City of Albuquerque

September 18, 2003

Re: Arno Subdivision Grading and Drainage Plan
Engineer's Stamp dated 8-11-03 (J14/D146)

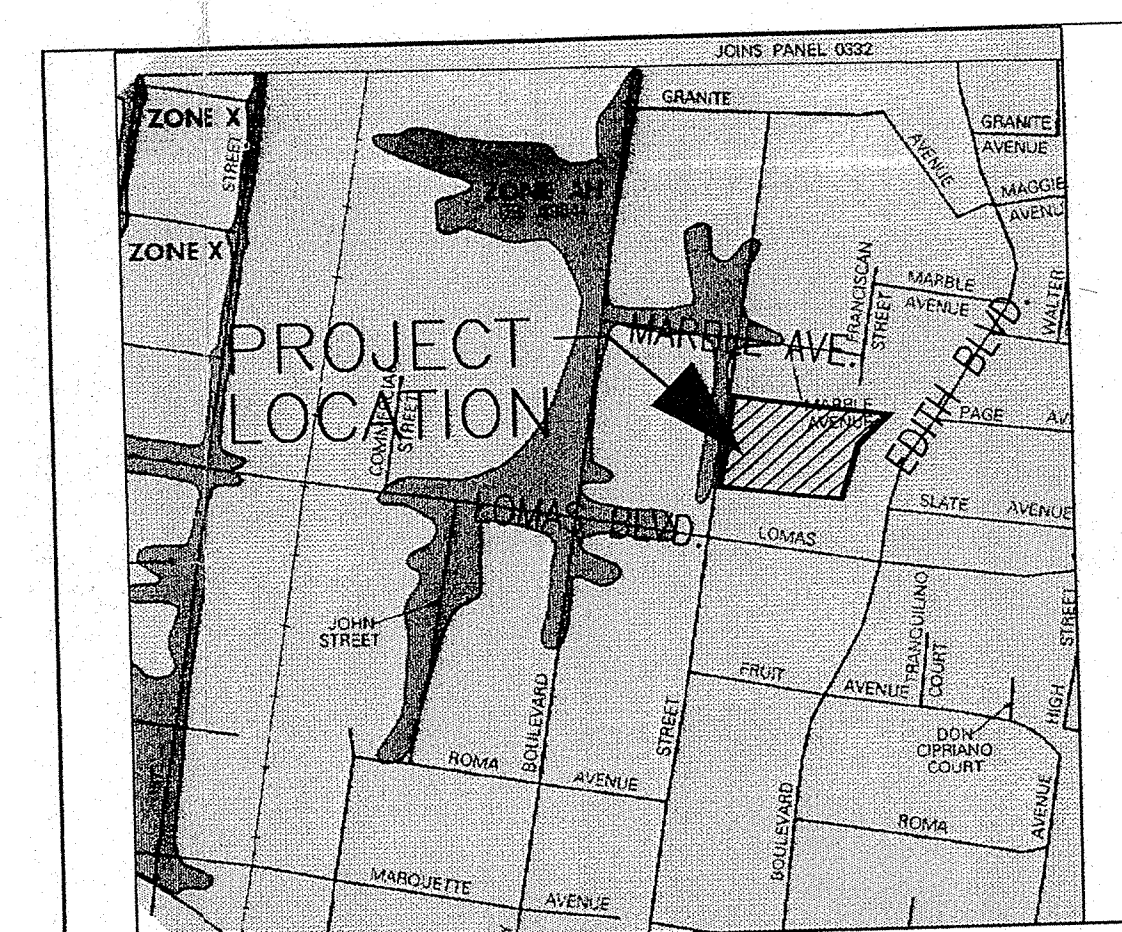
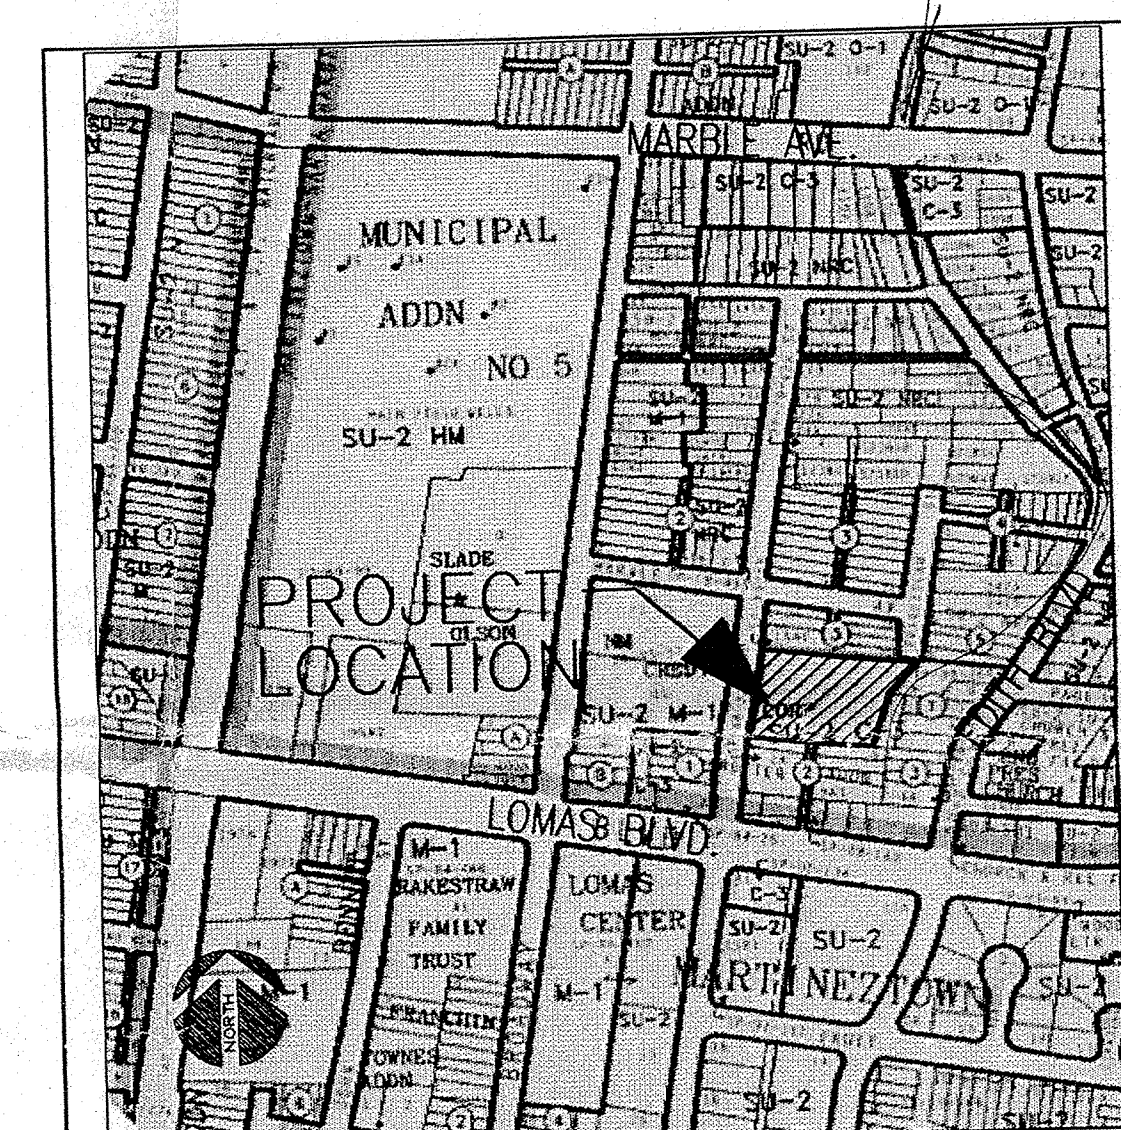
- The DPM states that the normal depth can be no higher than the top of curb and the depth plus velocity head ($d+v^2/2g$) cannot exceed 0.2 feet above the top of curb. There will need to be a transition to standard curb somewhere near Arno.
- The retaining wall must be made of masonry or concrete. Railroad tie retaining walls don't work to divert water and the City has had a fair number of complaints from homeowners whose walls have failed. Who will maintain the sediment pond and swales?
- Please provide the benchmark on the plan.
